CUMBERLAND
CITY COUNCIL

Ref: OA2020/0013

Subject: Request for comments-State Significant Development (SSD)
Application No: SSD-10407
Property: 14 & 16 Kiara Crescent YENNORA NSW 2161
Proposal: Ministerial Consent - Expansion of existing liquid waste treatment facility for increasing processing and storage quantities and hours of operations to 24/7

1 Swept Path 3
1 : 200

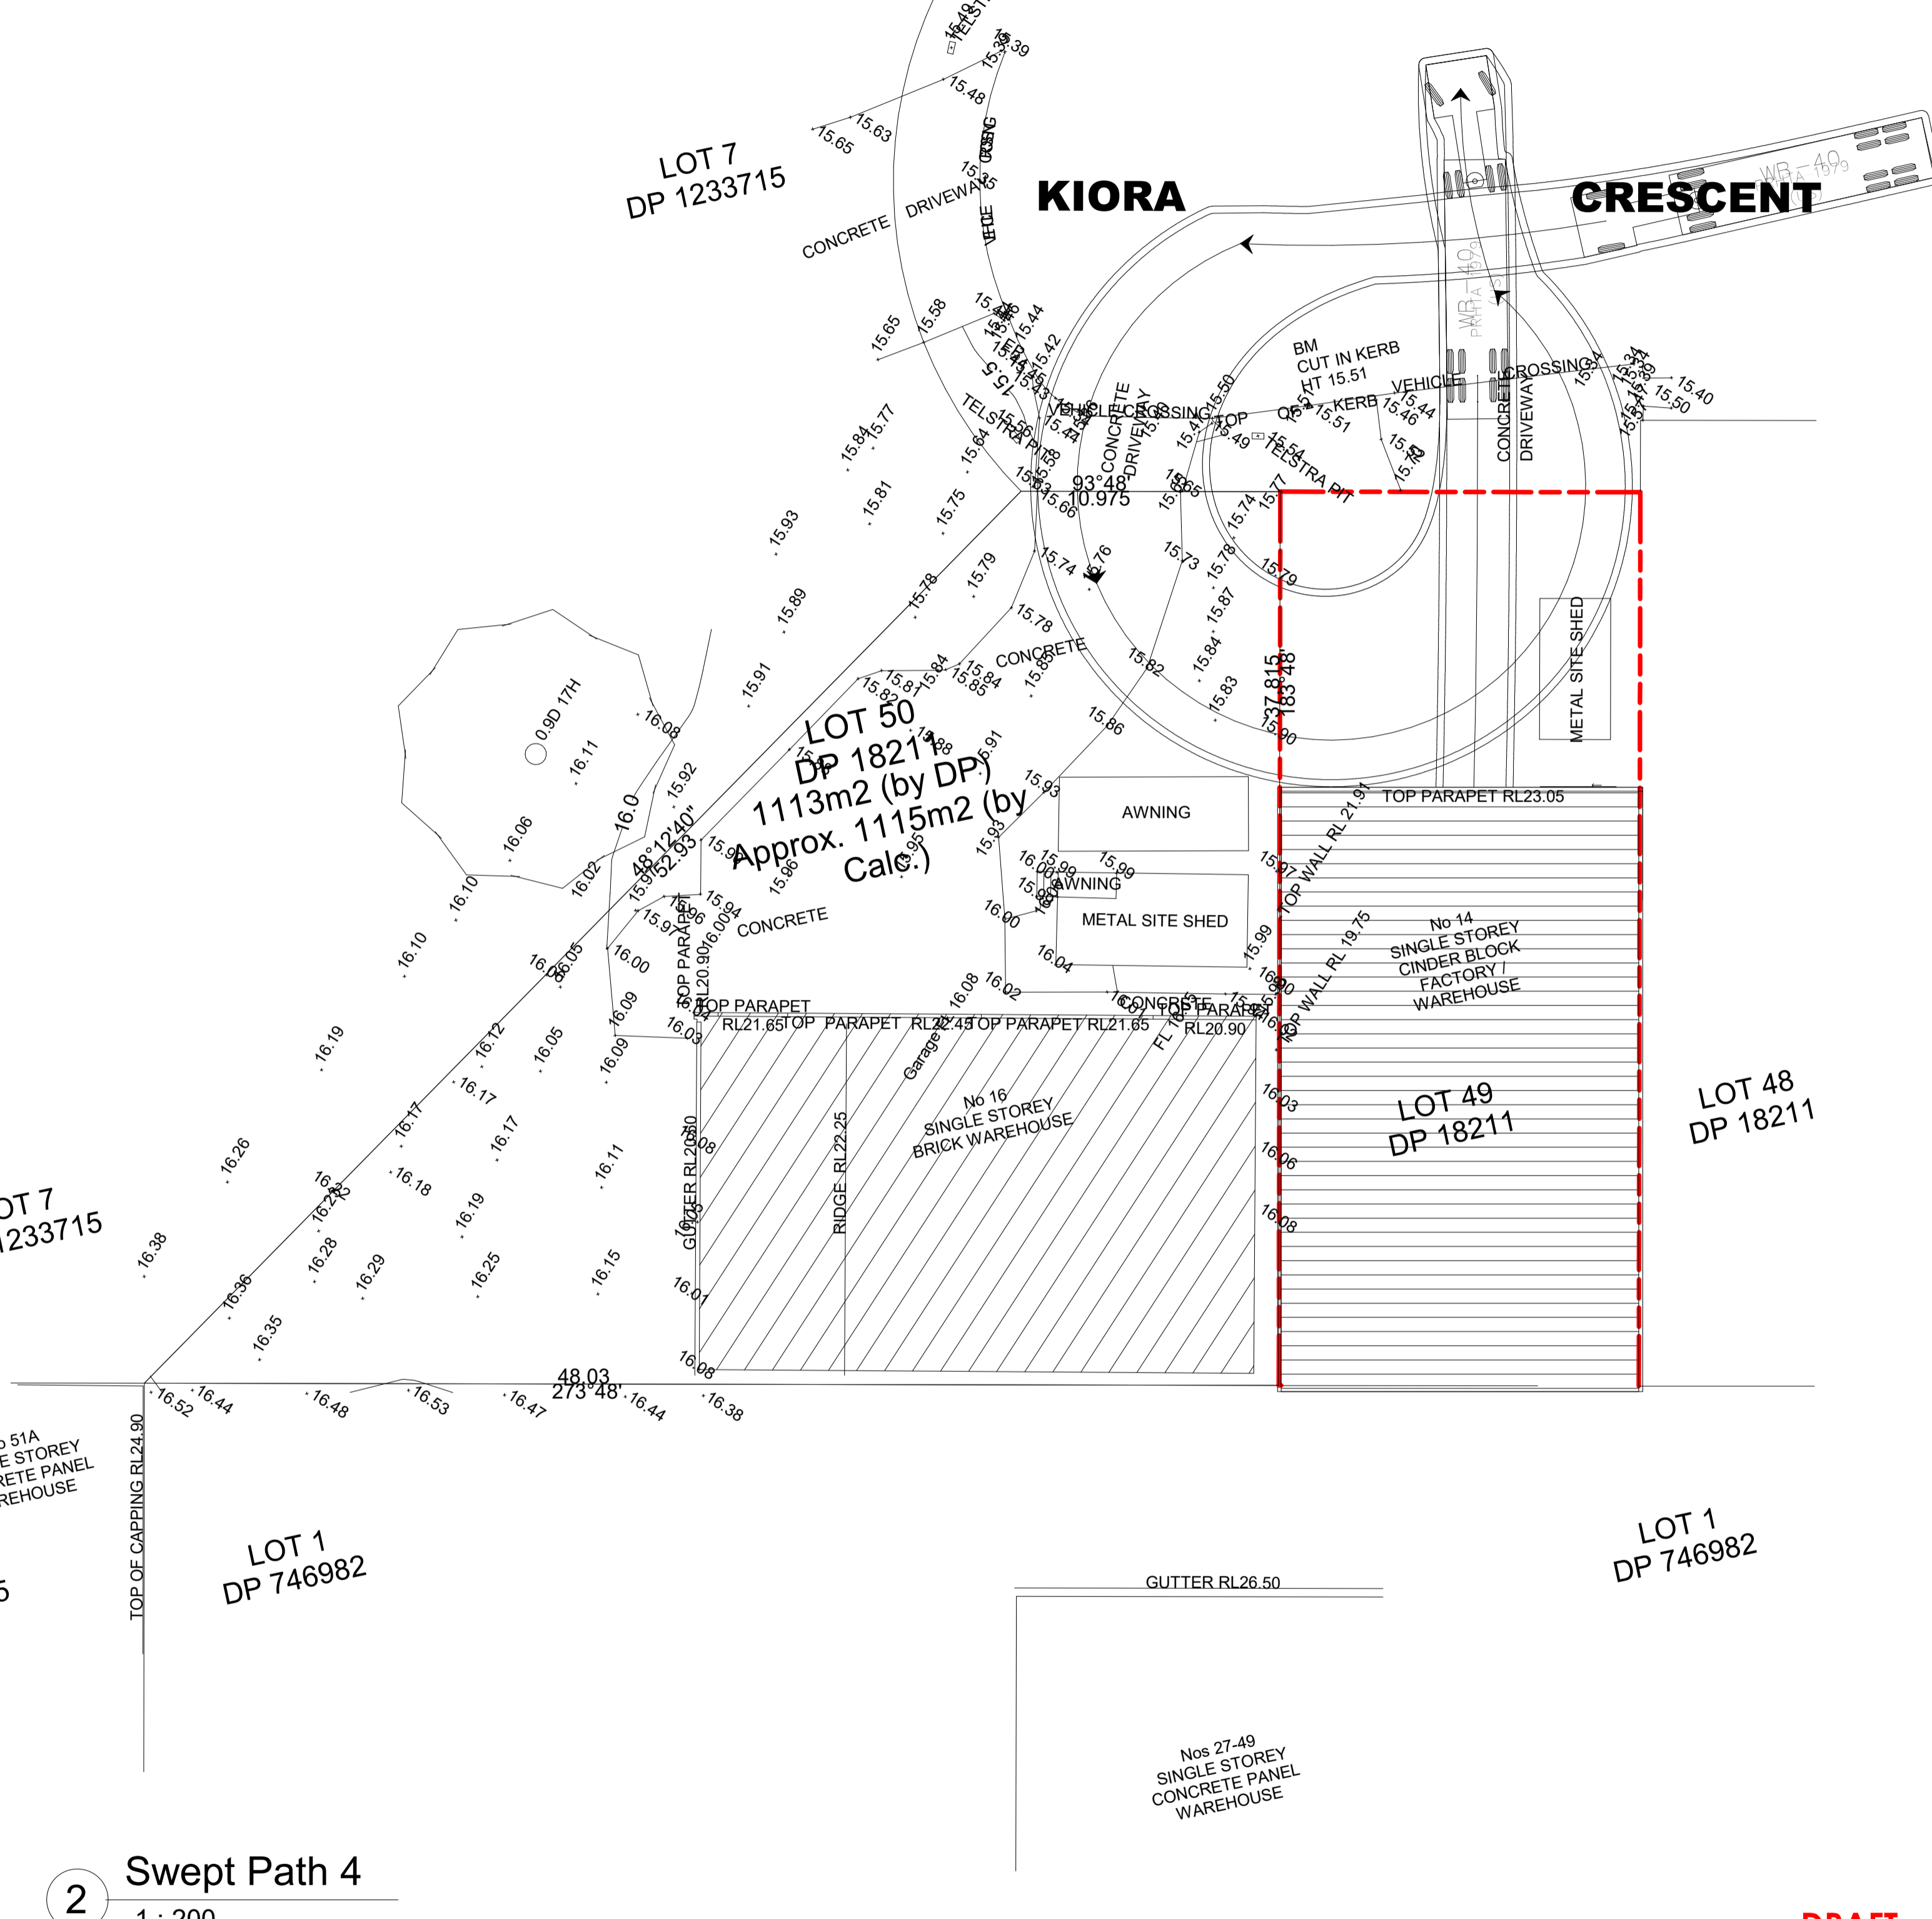
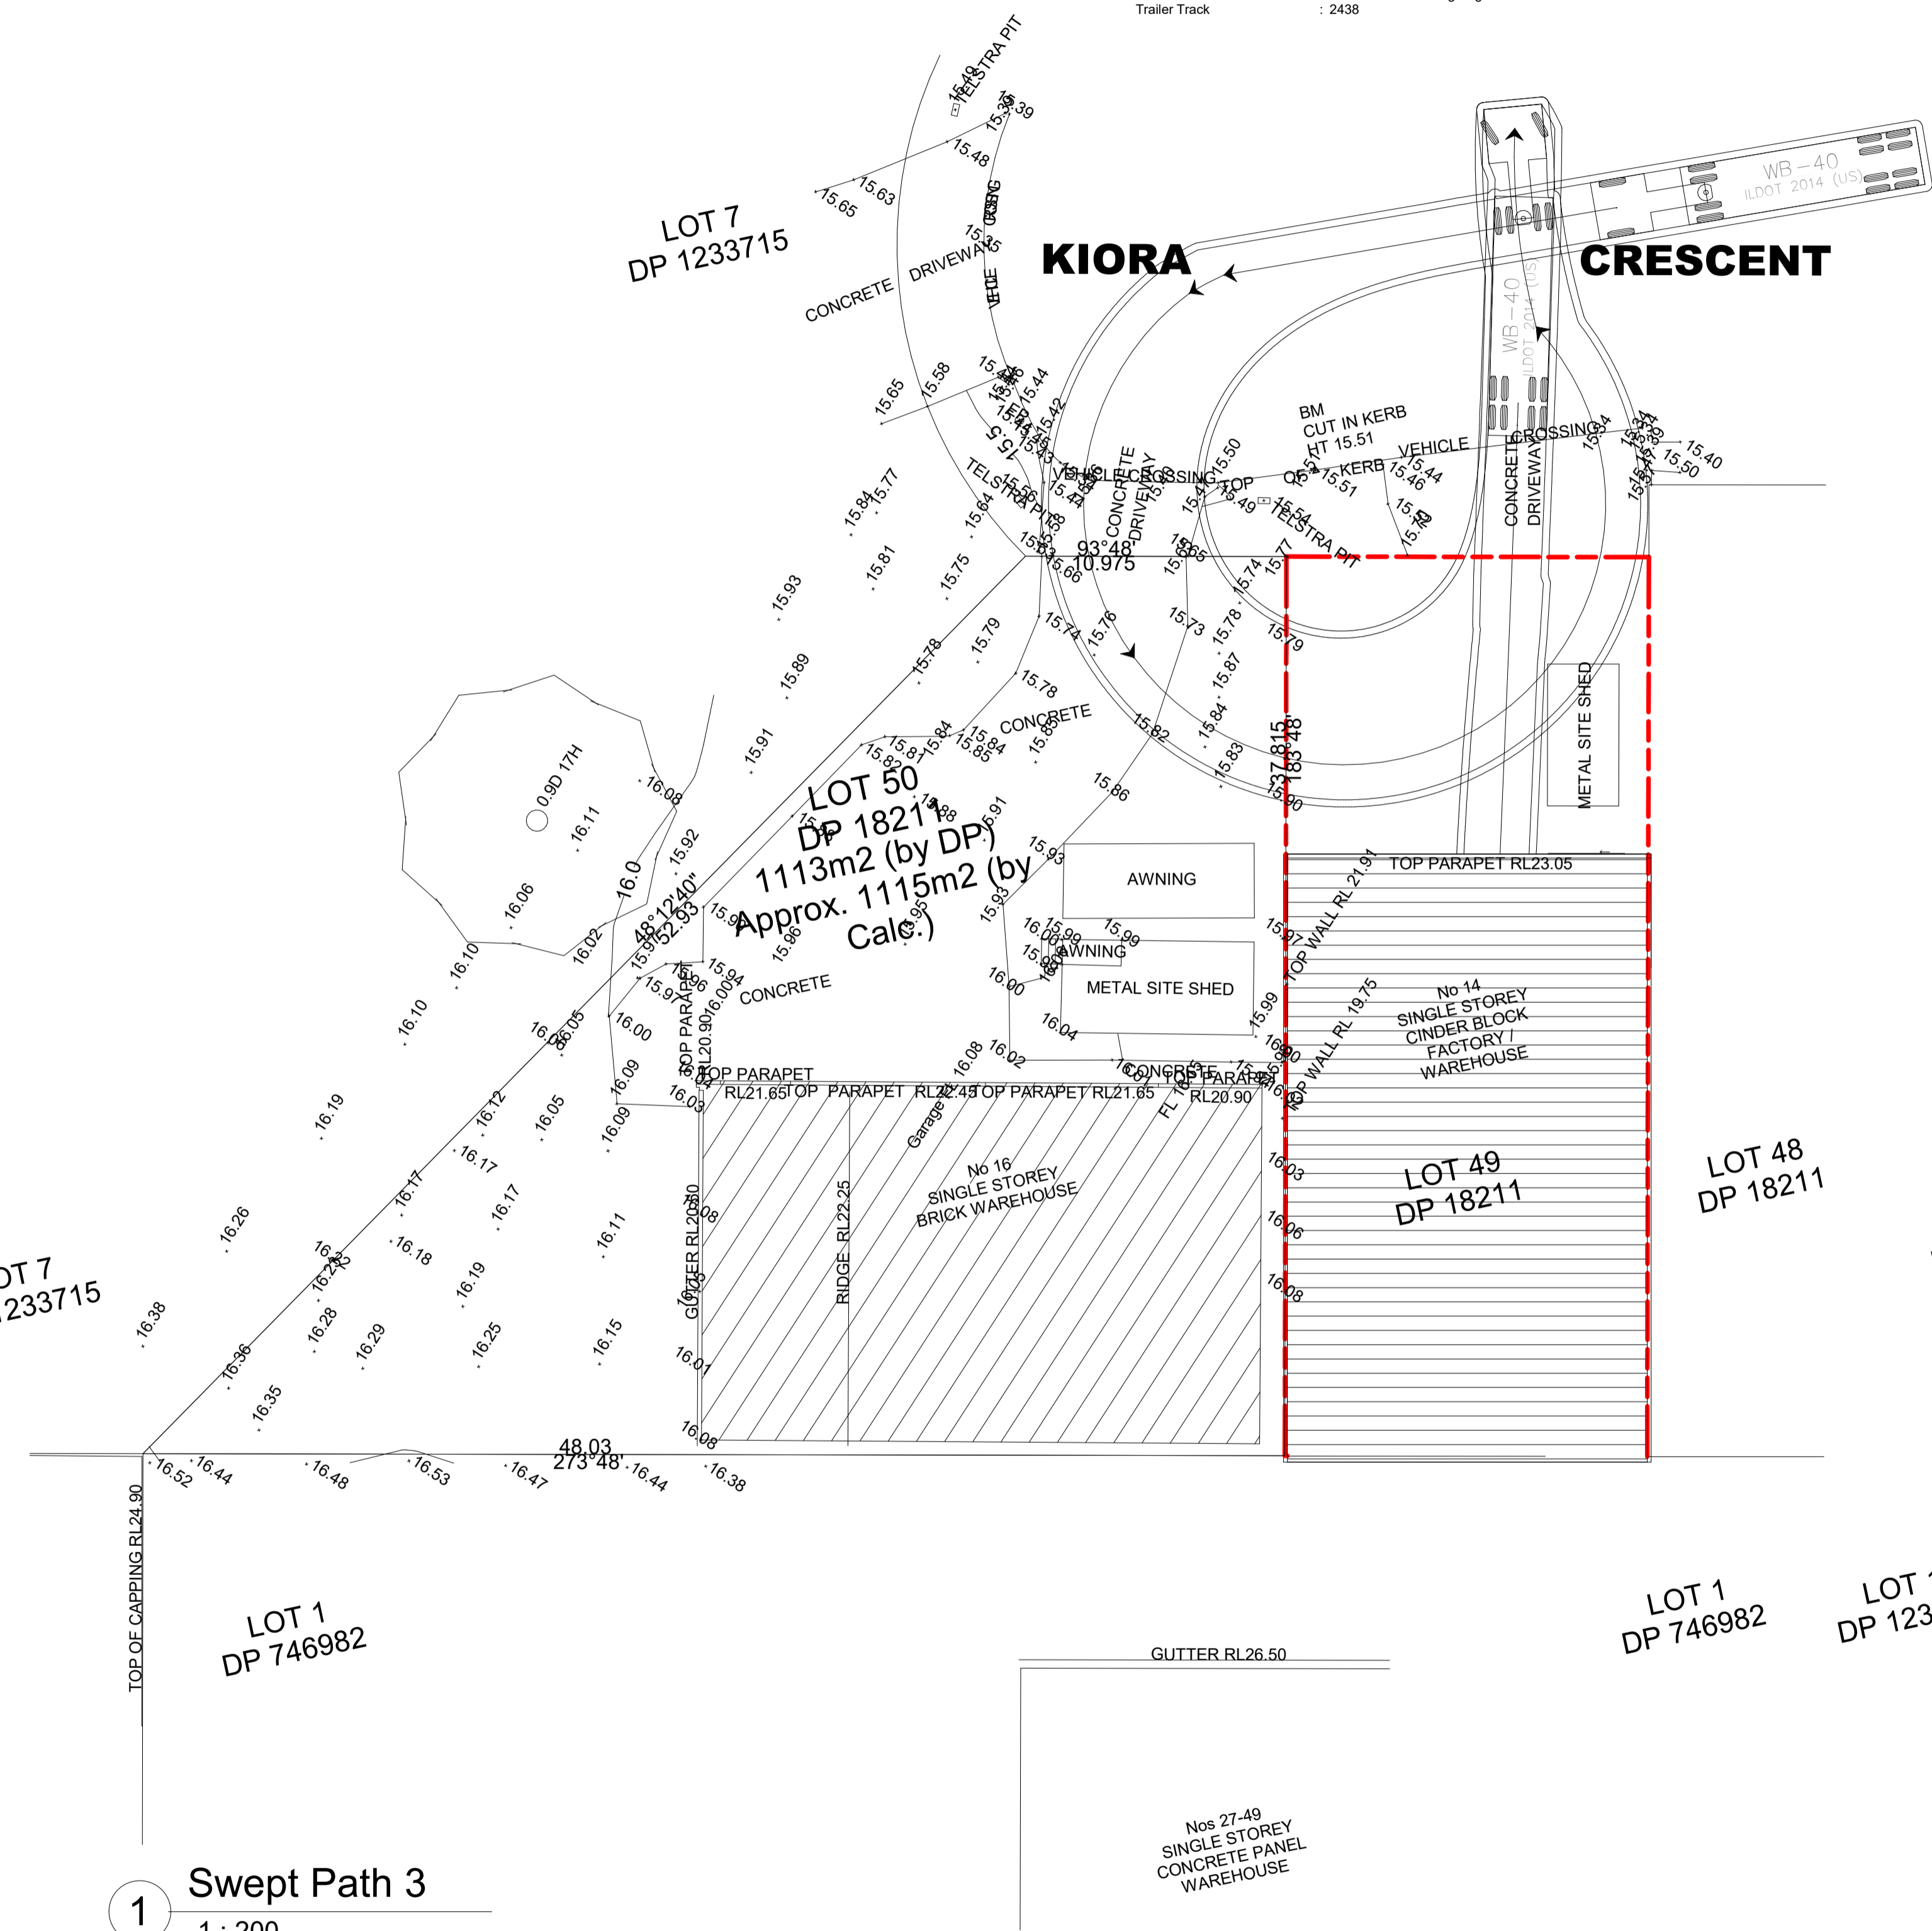
- a) The 10.0m truck used in the swept path analysis is not a standard truck that is defined in Australian standard AS2890.1. Further, the swept path clearance turning with 12,5 standard turning circle must be used.

- b) The manoeuvring and turning of the vehicle must be completed within the site and must not cause encroachment into nature strip or the footpath. The swept path diagrams demonstrate otherwise with the encroachment into nature strip.

- c) Sufficient swept path diagrams must be provided to demonstrate that the turning and manoeuvring of the truck is possible for all, entry and exit for both processing plant. The swept path must demonstrate with a truck in the waiting/stand-by bay.

- d) Further, the Truck swept path diagram also indicates the runover into the structure (entrance door jamb) and the car space for 16 Kiora Place.
- e) Reverse manoeuvring in Council's land is not acceptable. It will compromise the safety. Vehicles should enter and leave the site in a forward direction.

- f) Multiple point turn (more than 3 points) will result in additional time for the turning and manoeuvring thus overlapping with the arrival of another vehicle (truck) and causing obstruction and delay. Enough space must be provided for manoeuvring and turning with the minimum delay. The proposed 4-point turn truck manoeuvring movement is not acceptable. Manoeuvring shall be limited to three-point turn.

- g) Parking and loading design must comply with Australian standard AS2890.1 and AS2890.2. Further the design vehicle into consideration for the swept path analysis must be as per AS2890.2 (not UK standard as noted on the swept path diagram).
- h) The estimated peak hour traffic generation of the waste trucks is based on the assumption that the processing plant is operational 24 hours a day, 7 days a week. However, this is subject to the approval of the proposed operational management plan. Any variation to the operational hours will result in the increase in the frequency of the truck traffic. In such case the following must be complied:
 - (i) The traffic impact report must be revised and demonstrate how this will not result in adverse impact.
 - (ii) Additional facility/ area for holding the waste
 - (iii) Additional facility/area for the trucks waiting for unloading the waste.
